ROAD SAFETY AUDIT – STAGE 1

**Residential Development
Cloghroe
Cork**
June 2021

Client	Cloghroe Development Ltd.
Project Title	Cloghroe Residential Development
Document Title	Road Safety Audit – Stage 1
Document No.	CRD_RSA1_D01
Job No.	19083HD

**Drawing Title:** Proposed Signalised Junction

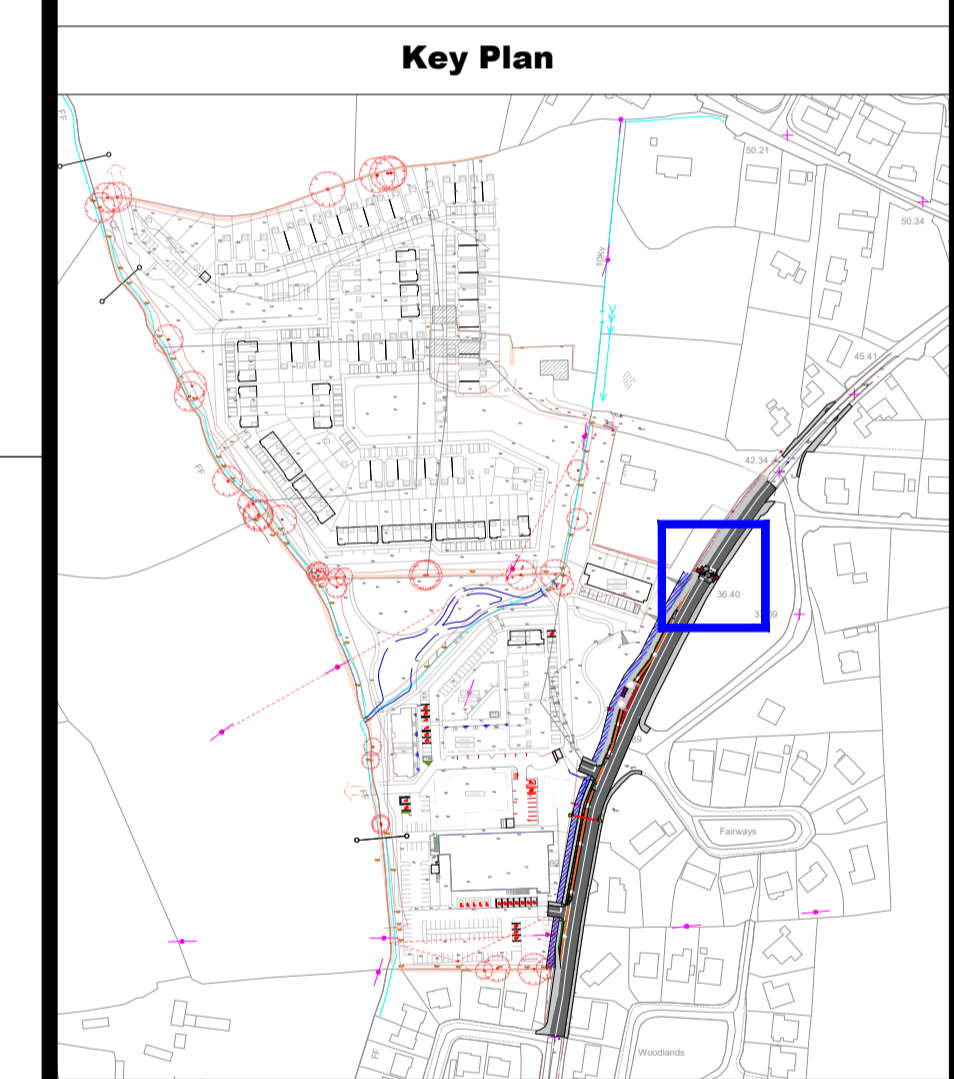
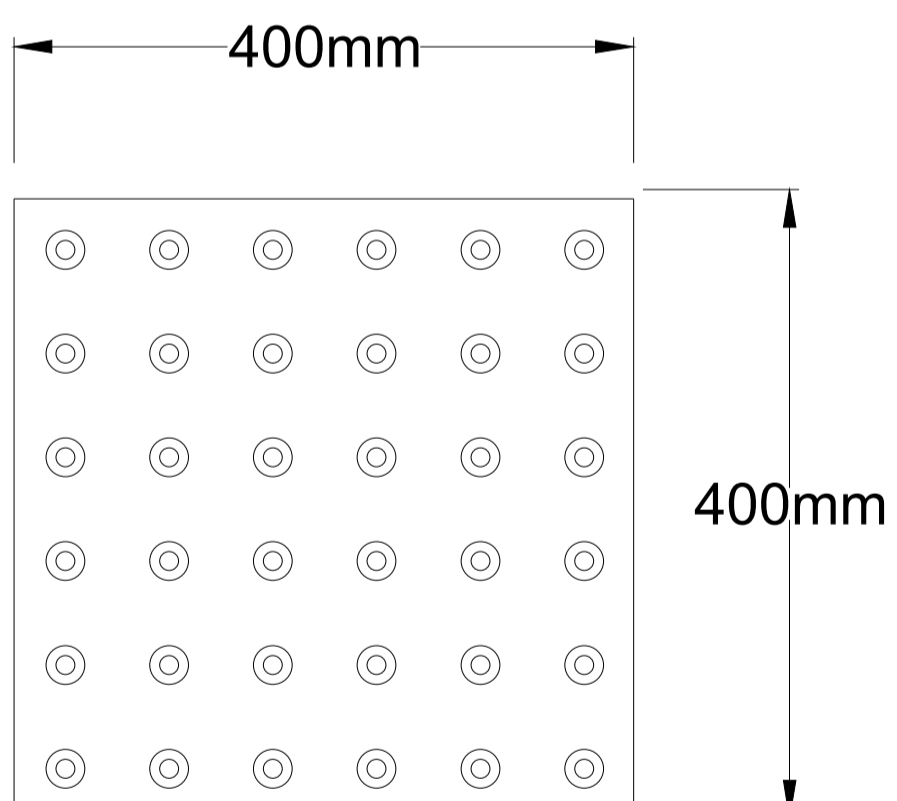
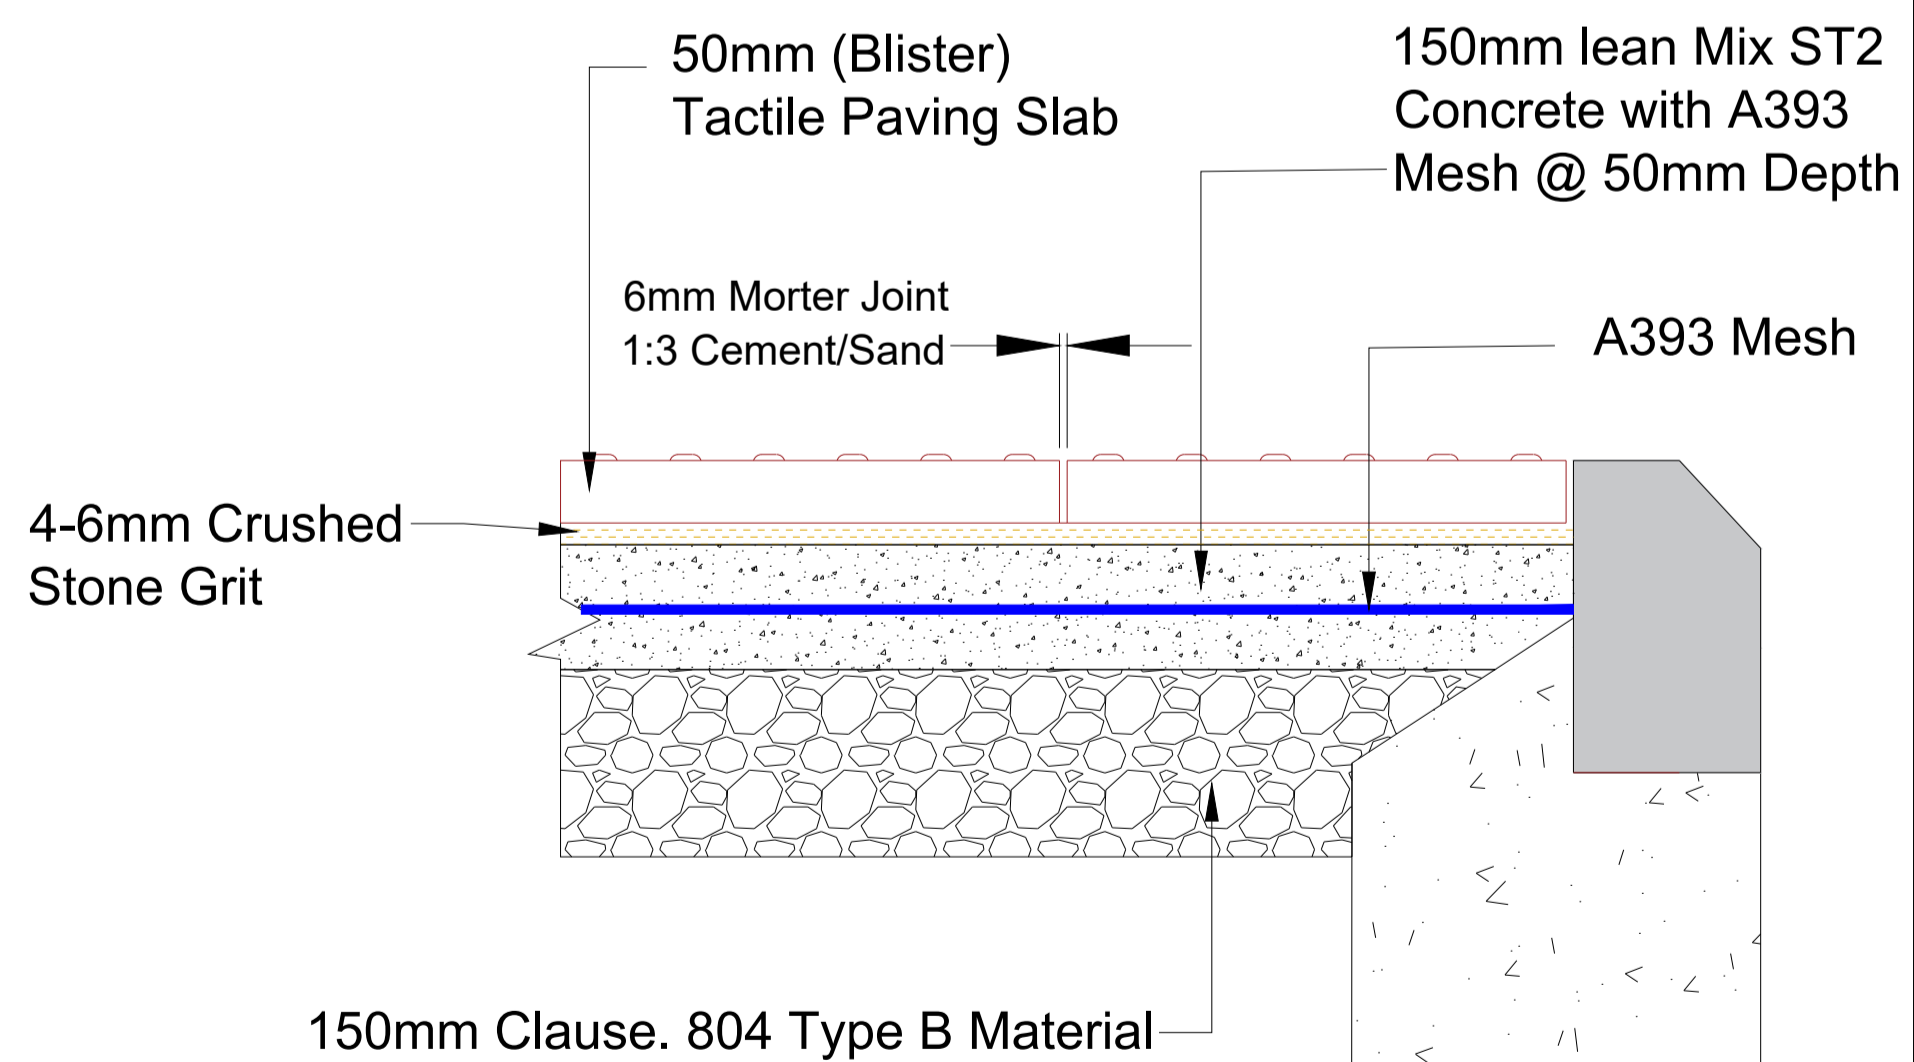
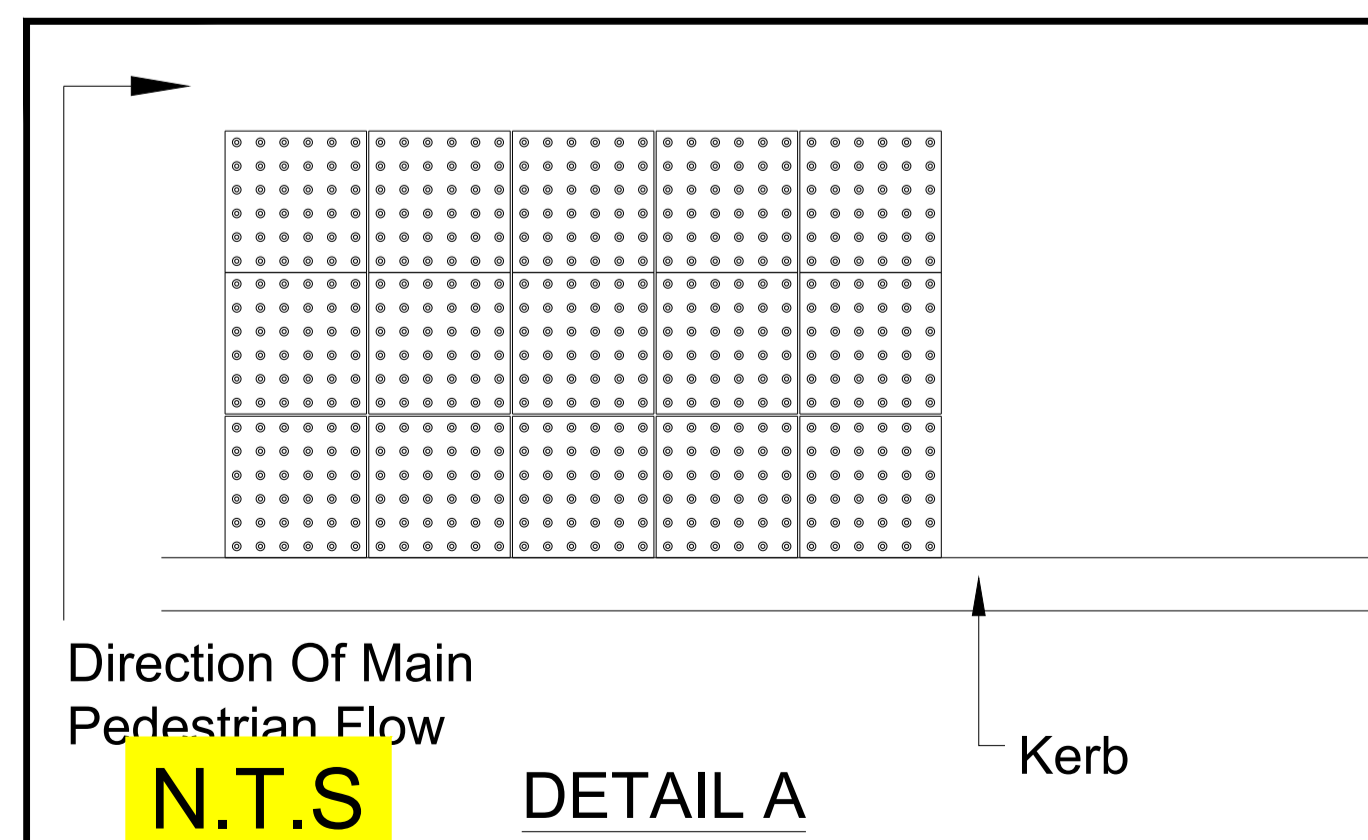
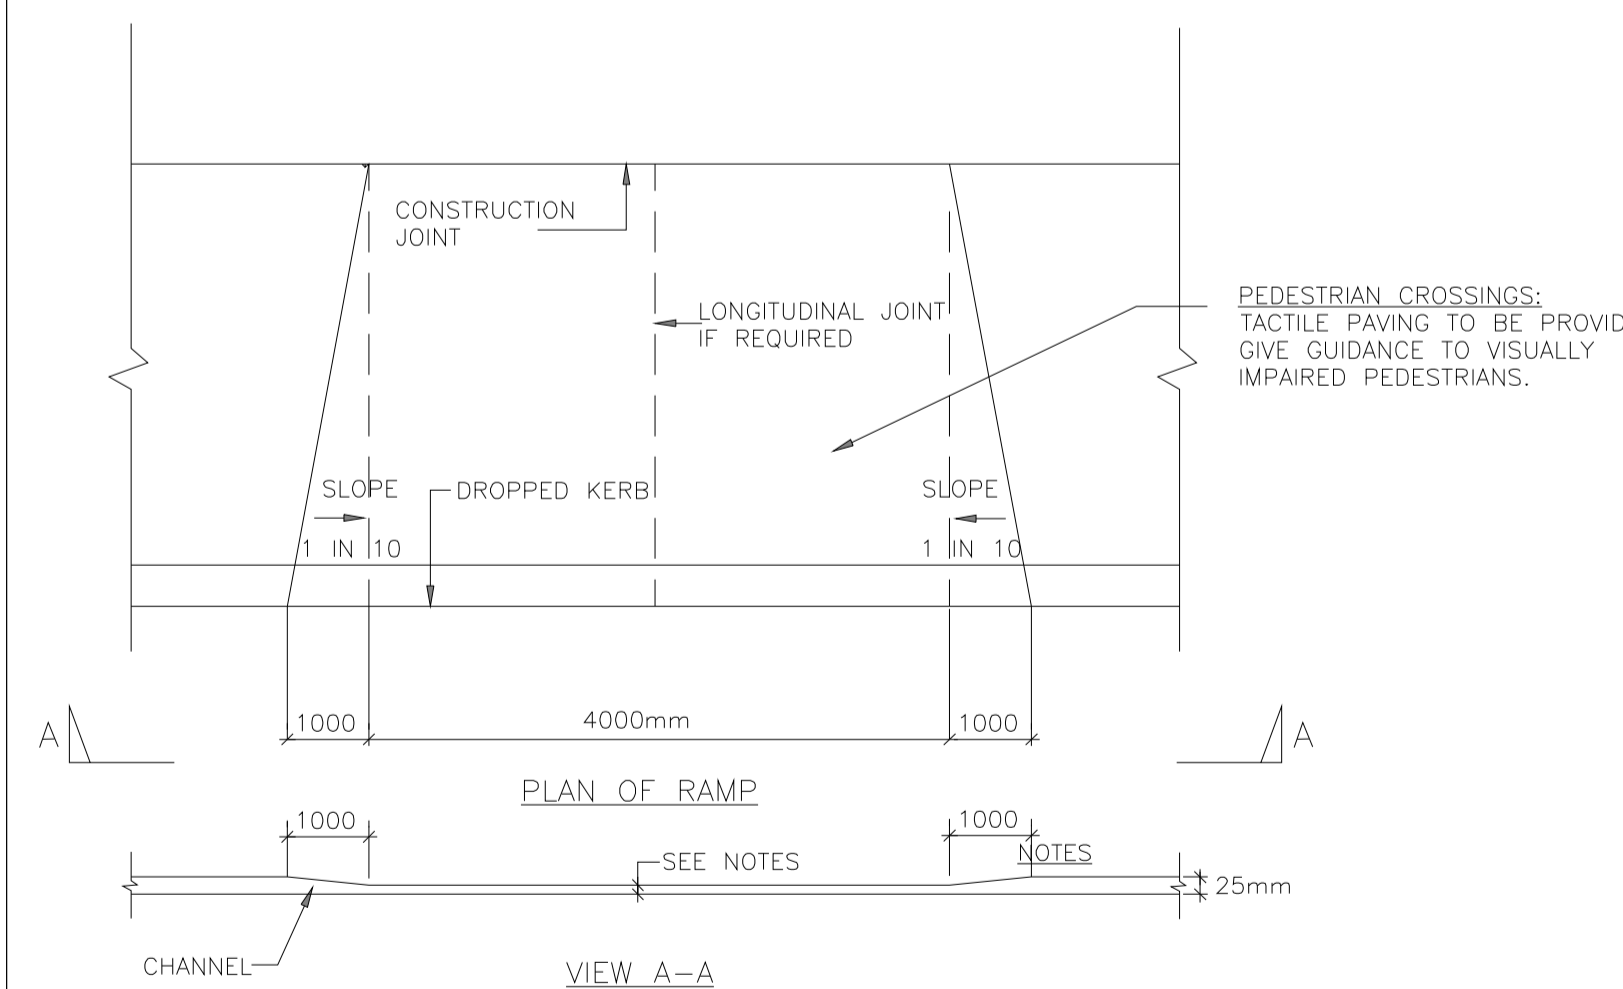
2.4 Problem: Advanced Warning Signage at proposed Controlled Pedestrian Crossing.

It is not clear from the drawing submitted for audit if signage on the approaches to the proposed crossing will be provided. Failure to provide adequate warning signage may lead to drivers failing to see the crossing point in time resulting in collisions between passing vehicles and crossing pedestrians.

Recommendation 4

Provide advanced warning signage in accordance with the Traffic Signs Manual.
